My ref: RLS/18/02/17/AR
Your ref: A/55/19/PL

11th June 2019

Revised Application for a single Dwelling.
Land at the Ninth Tee, Land North of Ashurst, Ham Manor Way, Angmering.
Your Ref: A/55/19/PL

Plans (1:50)

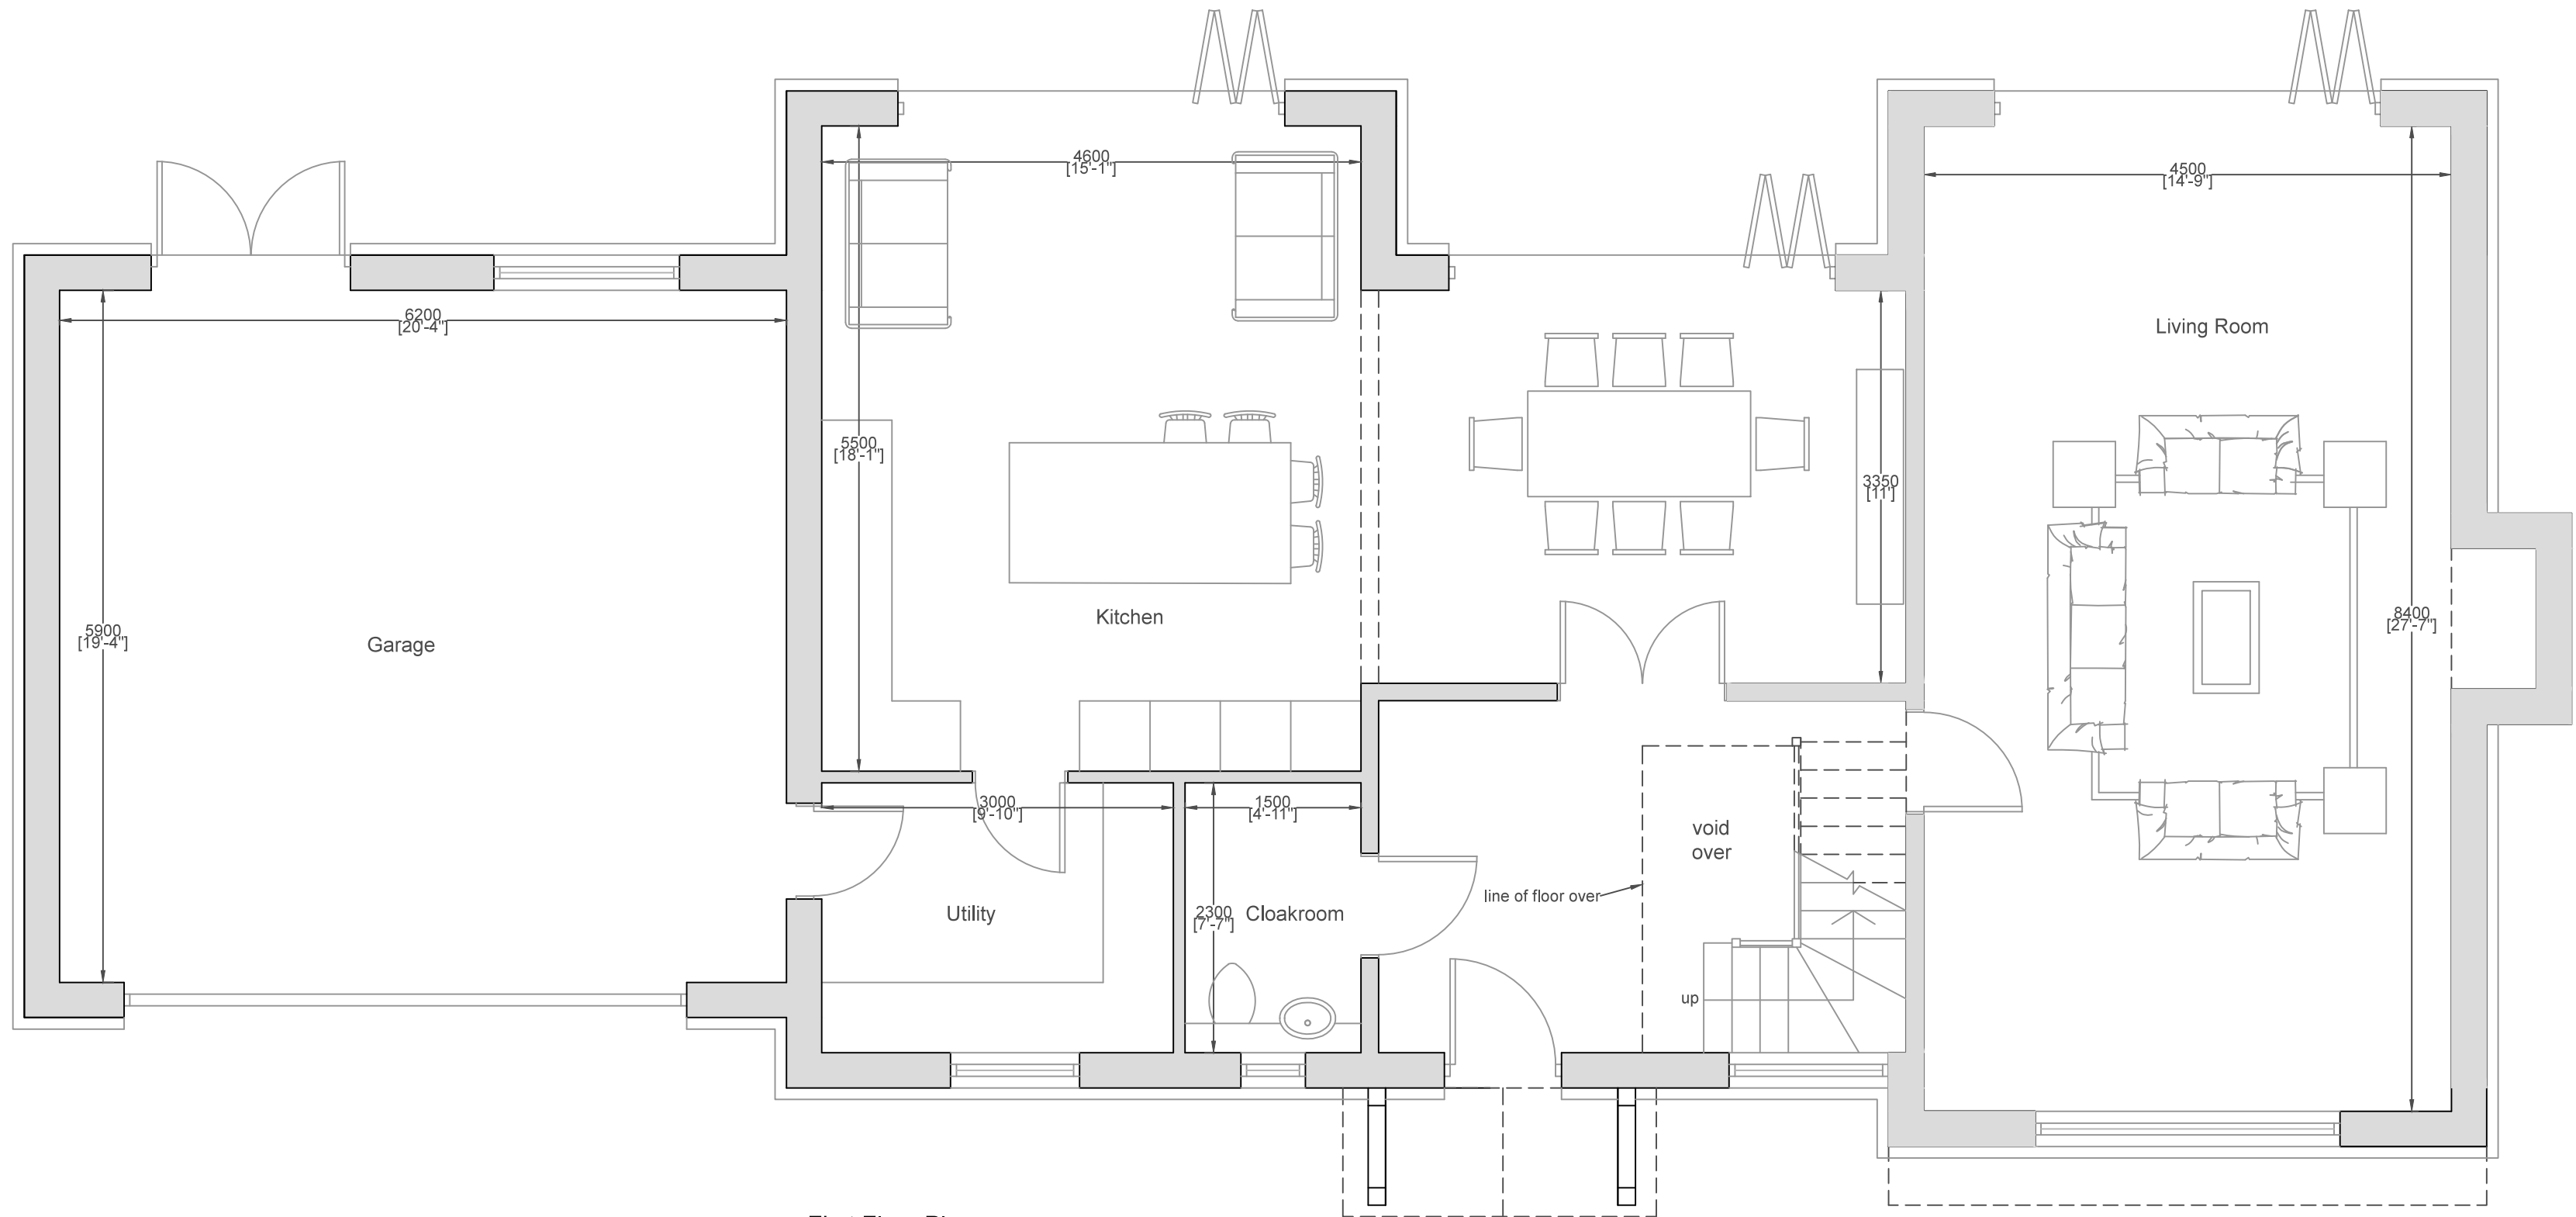
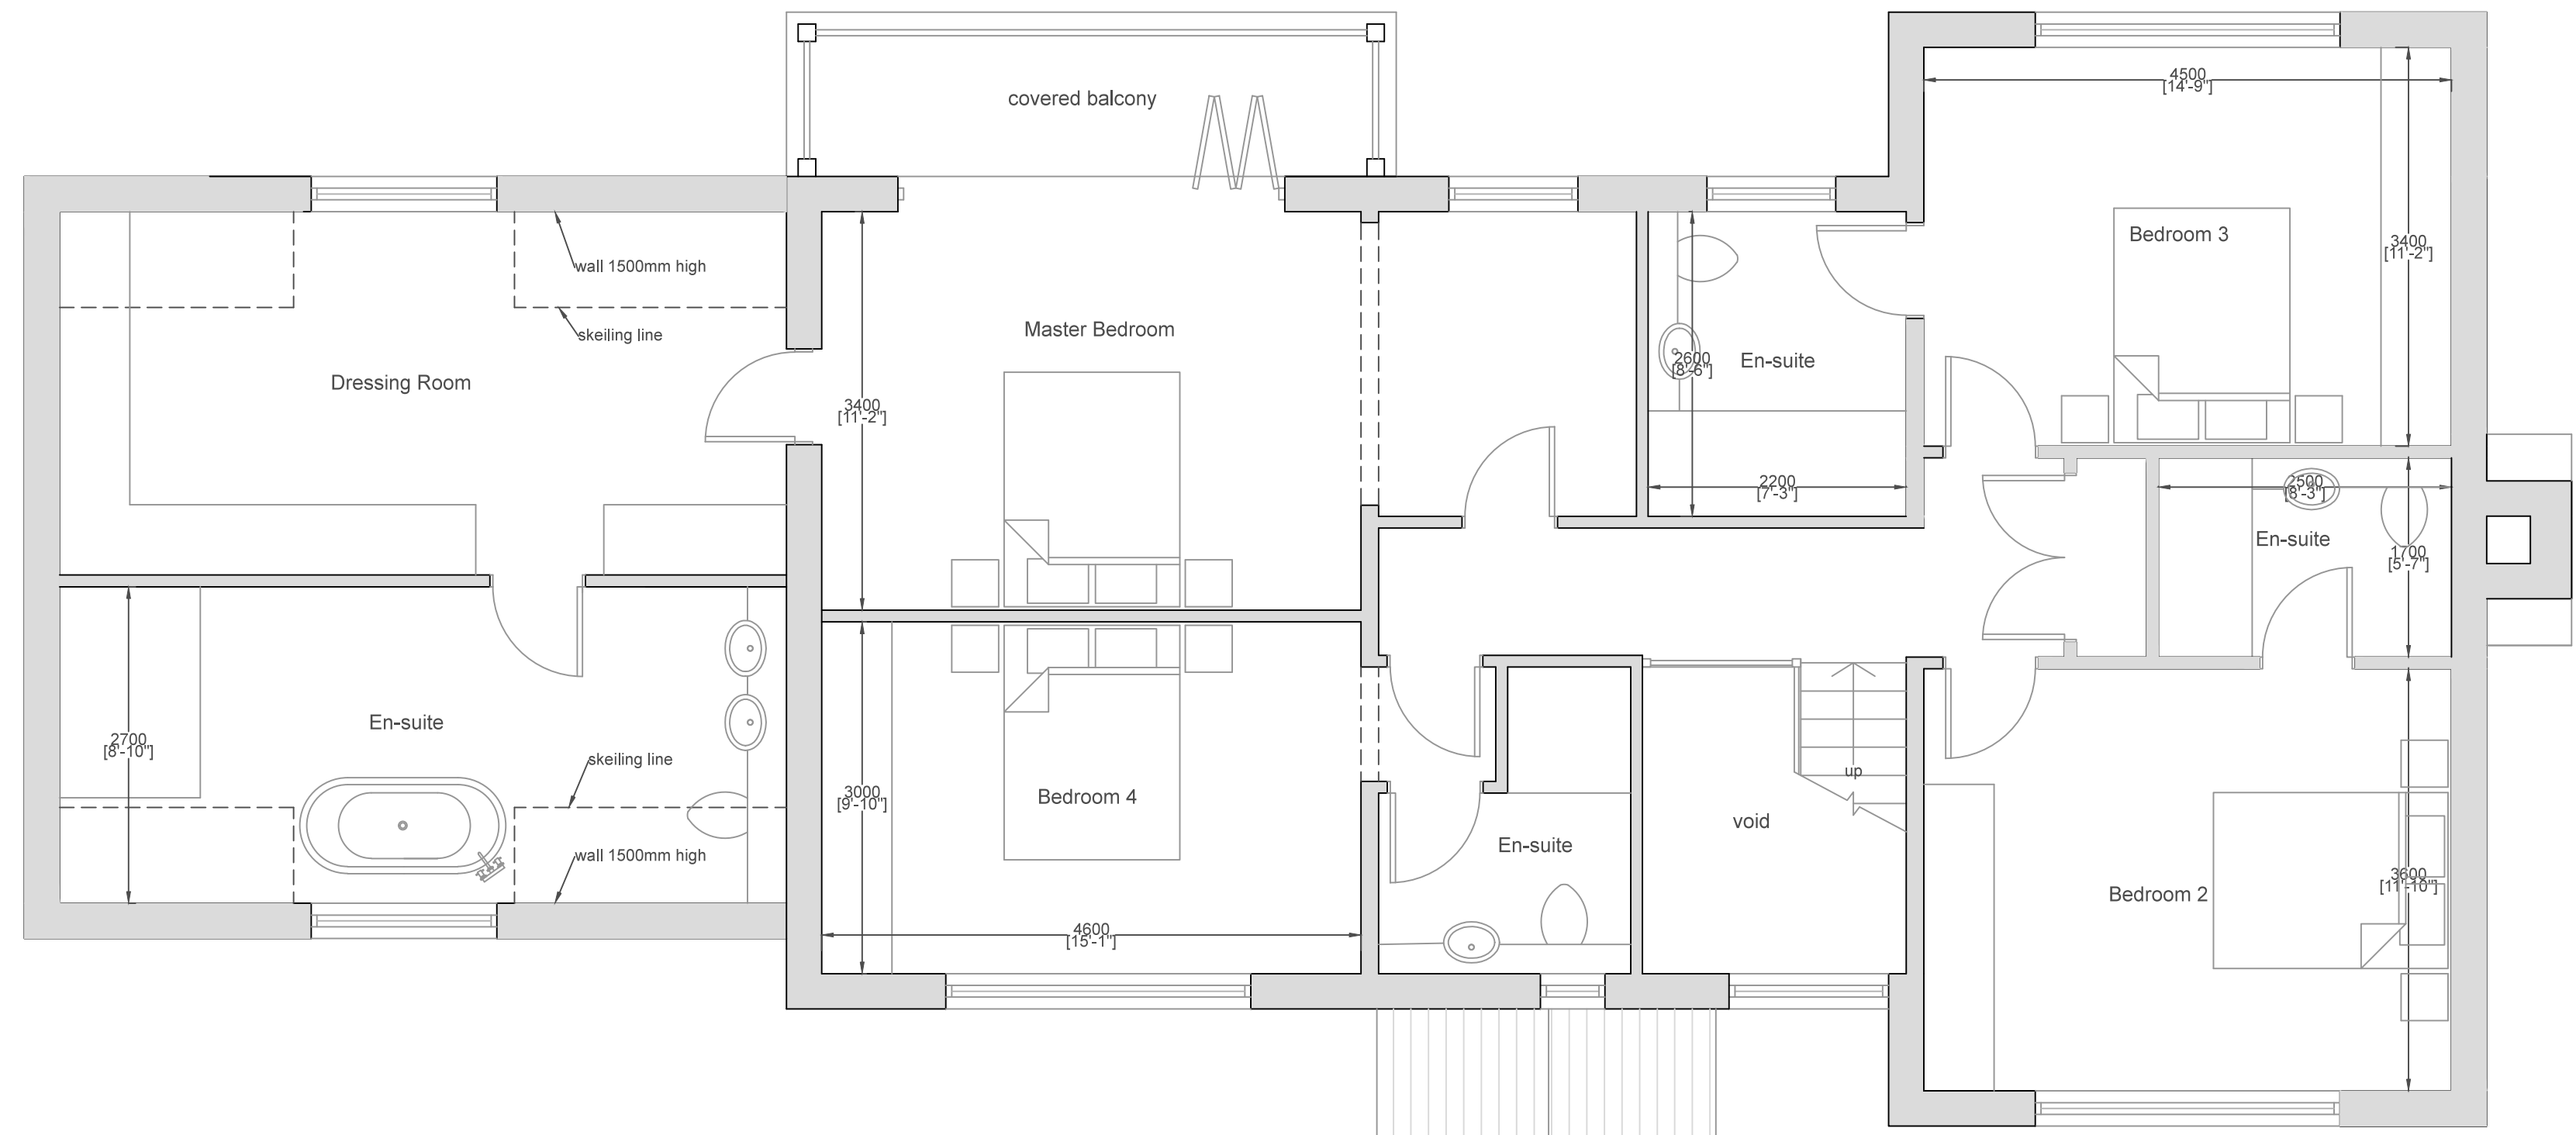
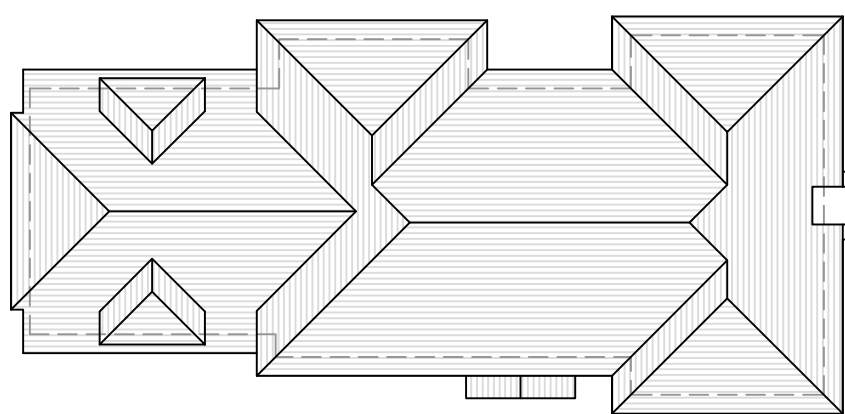
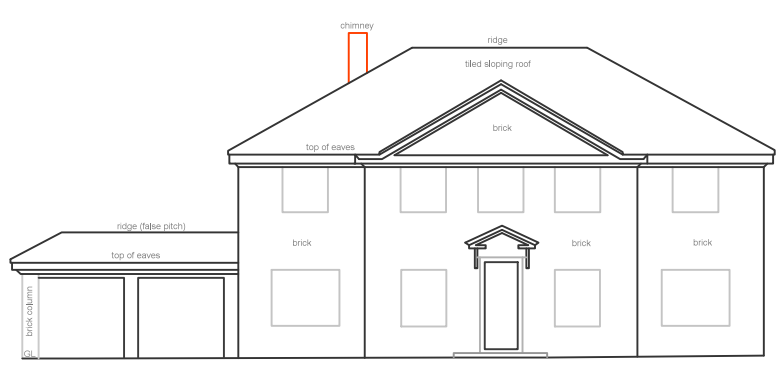
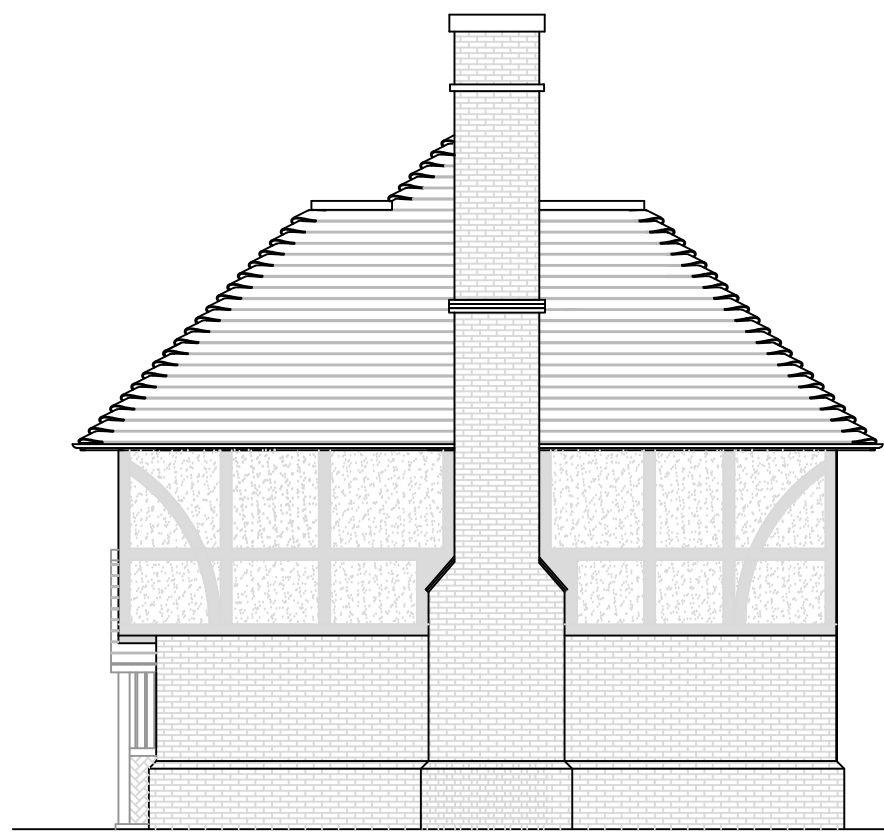
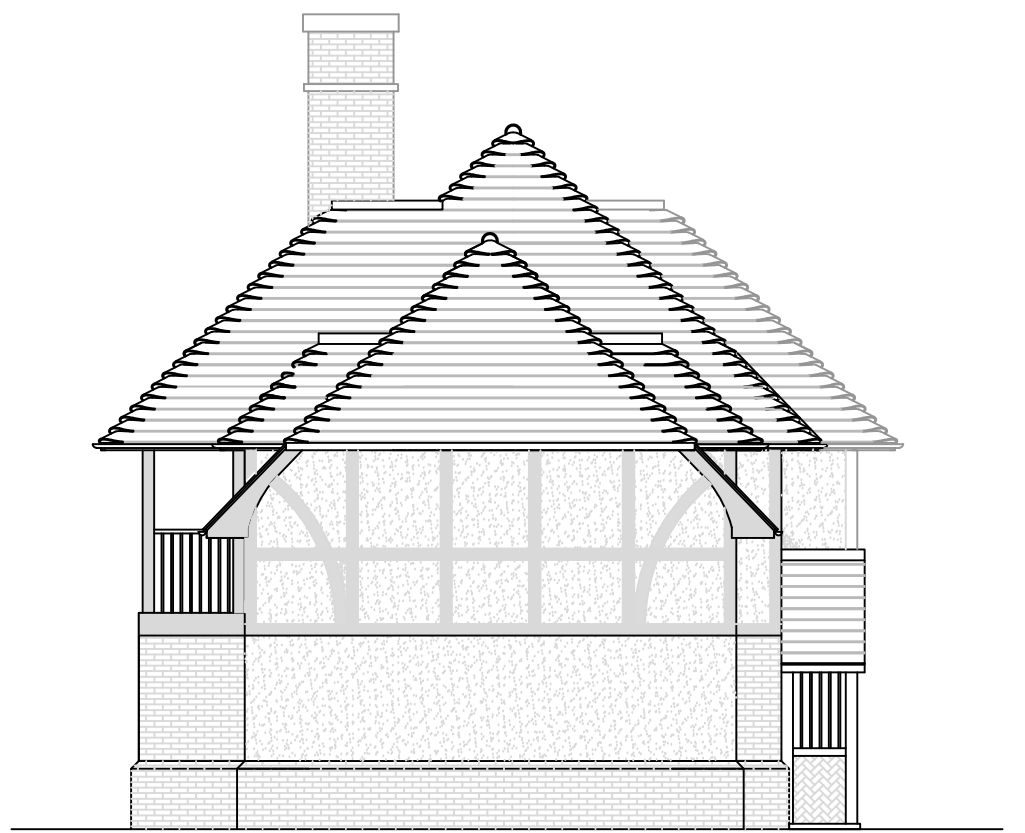
With regard to this proposal the applicant has amended the application drawing to show a narrower plot and a deeper rear garden. The dwelling itself remains the same and clearly breaches the guidance promoted by the Inspector in refusing the scheme for two units on the land because the dwelling clearly lacks in space within and about the site, being of a considerable weight and bulk, with no space within the developed site on the two sides as contributing to the character and sense of spaciousness within the overall plot.

In assessing the impact of this substantial dwelling on the character of the area the potential introduction of a second dwelling on the south side of this plot, unless lawfully removed by 106 agreement, remains and will result in a continuous line of built form which would be bulky and excessive having unacceptable impact on the overall charm, character and appearance of the area. It is clearly not acceptable in this protected countryside location of Local Green Space to allow what is a clear urban form of development in assessing and presenting dwellings on this site. Whilst Badgers may be of two-storey form the dwellings of Ashurst and all of those opposite the site of the development are of a lower form and bulk with, vitally, the original roof form and its eaves being at single storey height. It is clearly this style and form, with space to either side that should be correctly followed at this site.
